Application by Highways England for M54 to M6 Link Road

The Examining Authority's written questions and requests for information (ExQ1)

Issued on 20 July 2020

LEGEND

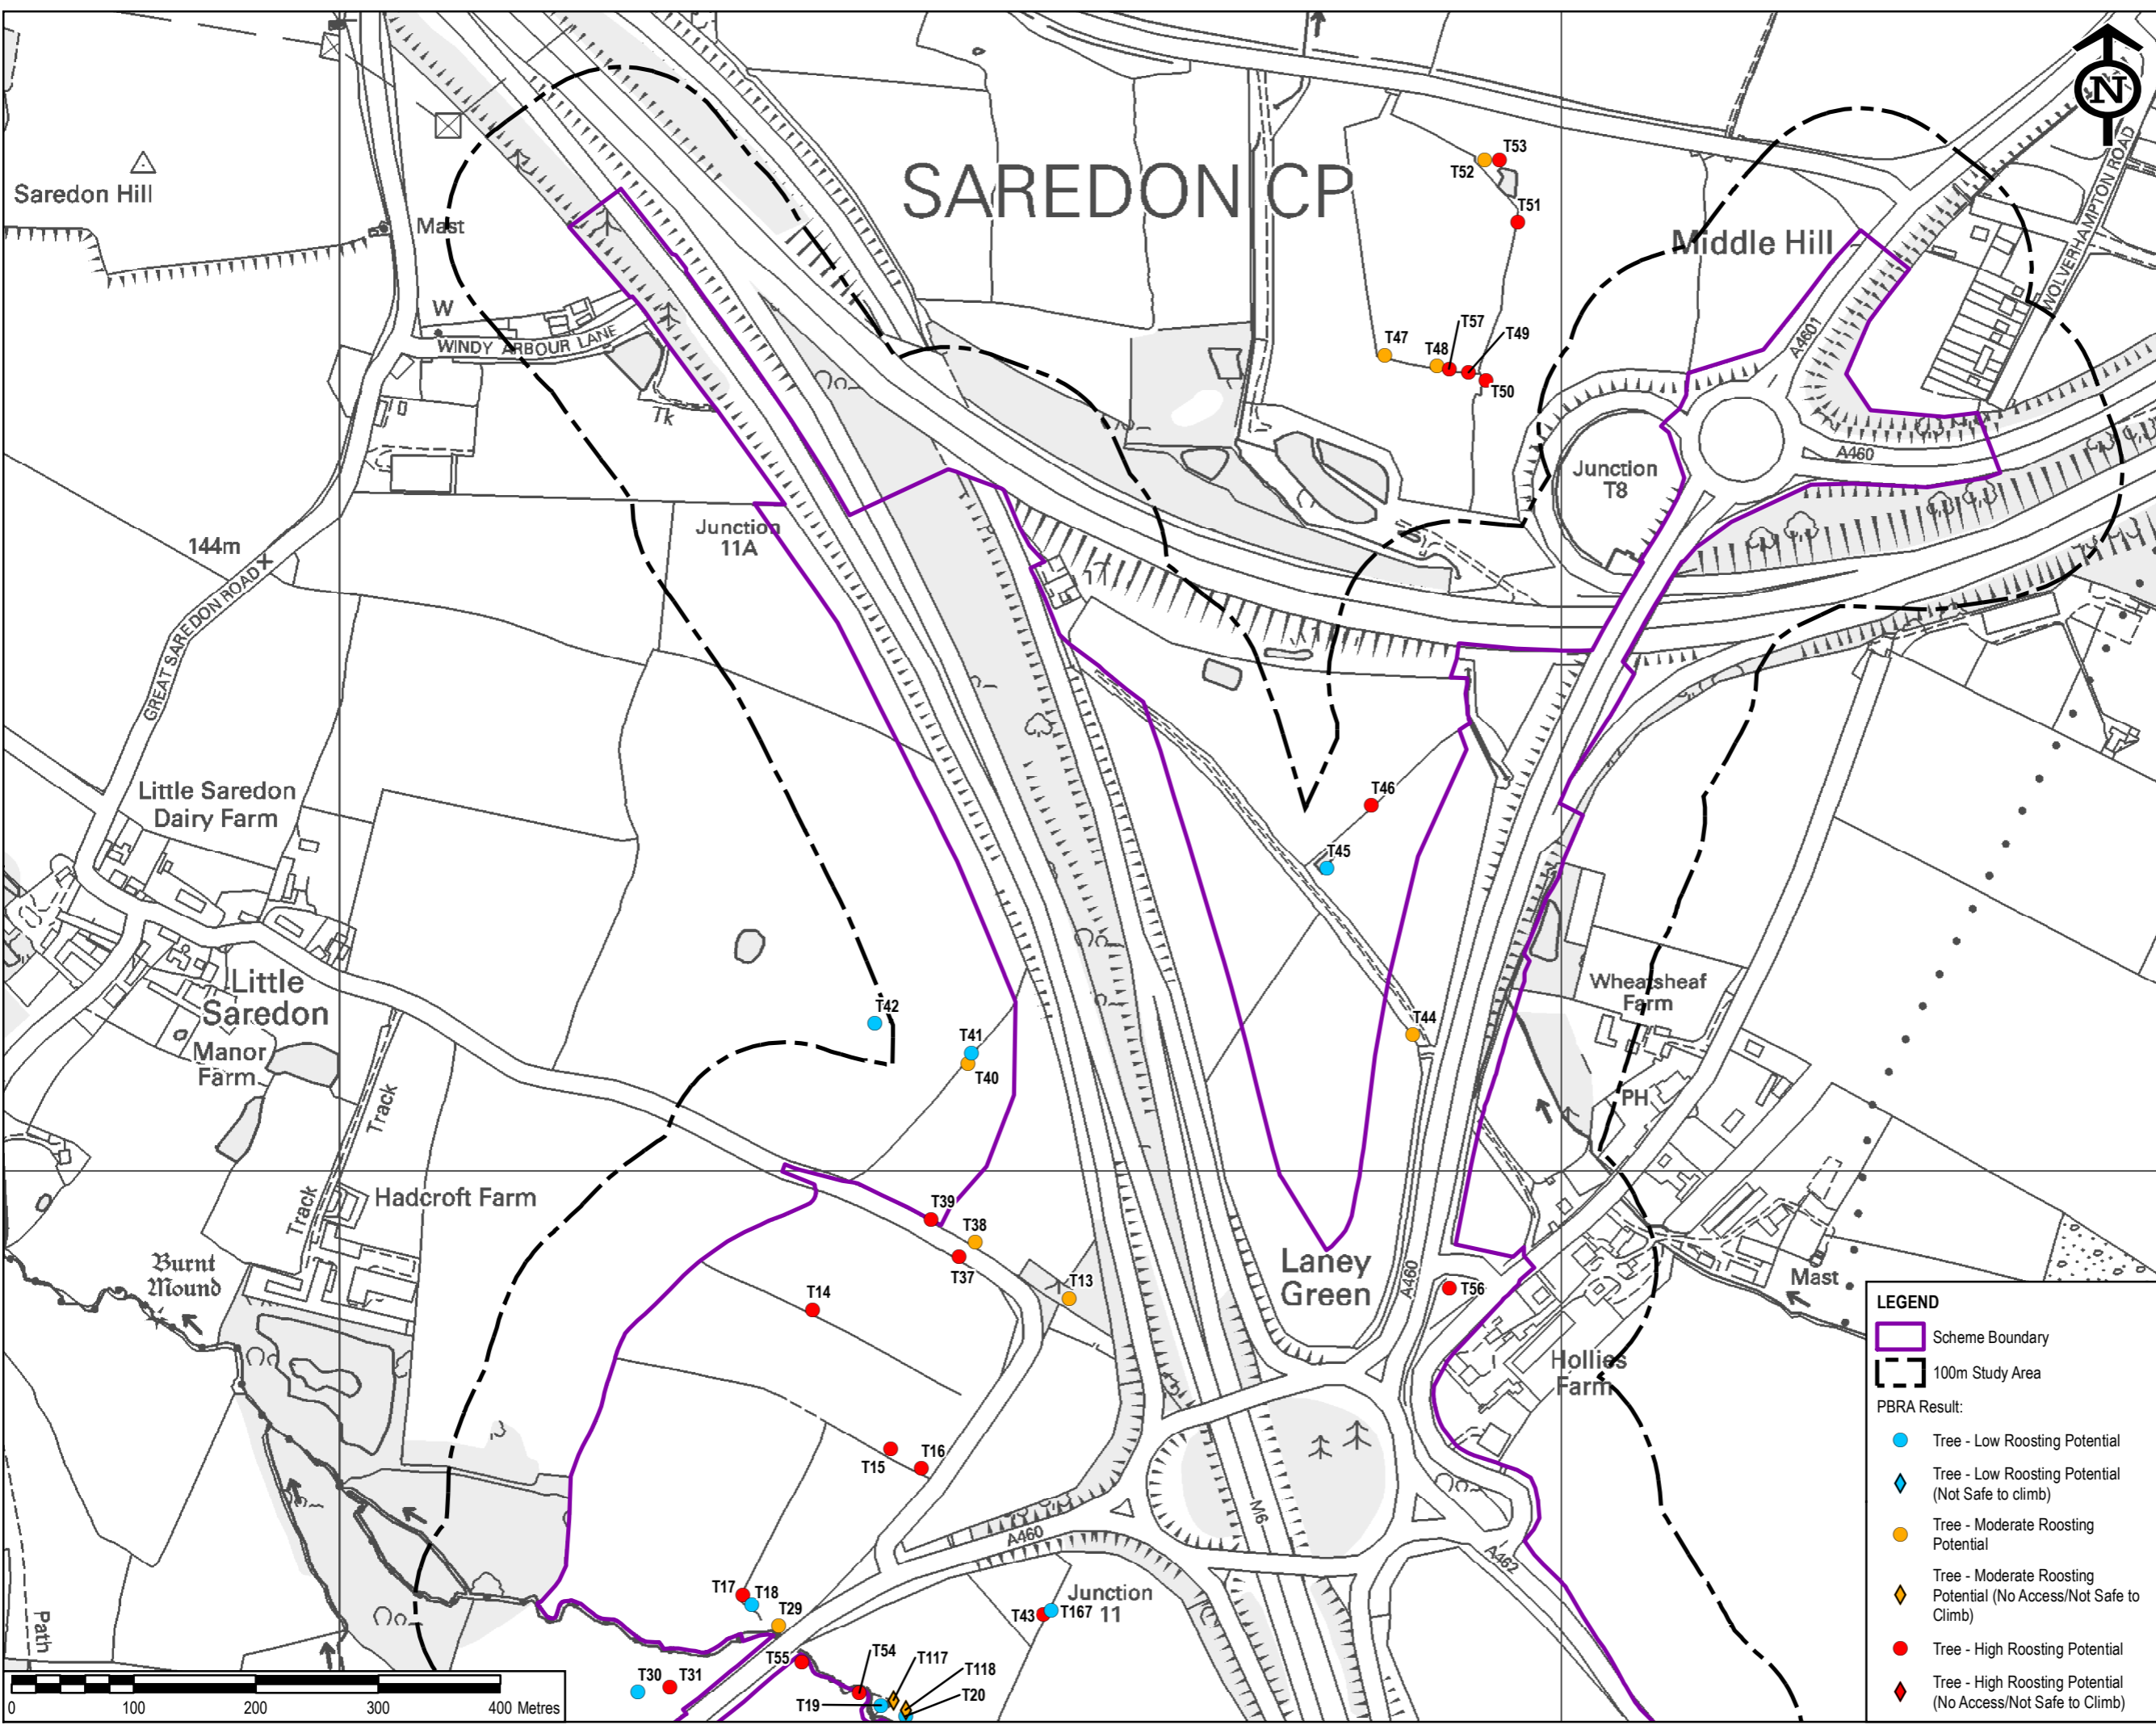
1.3.4.	The Applicant	Bats Paragraph 8.6.28 of Chapter 8 of the ES [APP-047] indicates two bat roosts within the boundary of the Proposed Development. However, in Figure 8.14 [APP-118] these two trees (T70 and T112) are given different classifications. Could this discrepancy be explained?
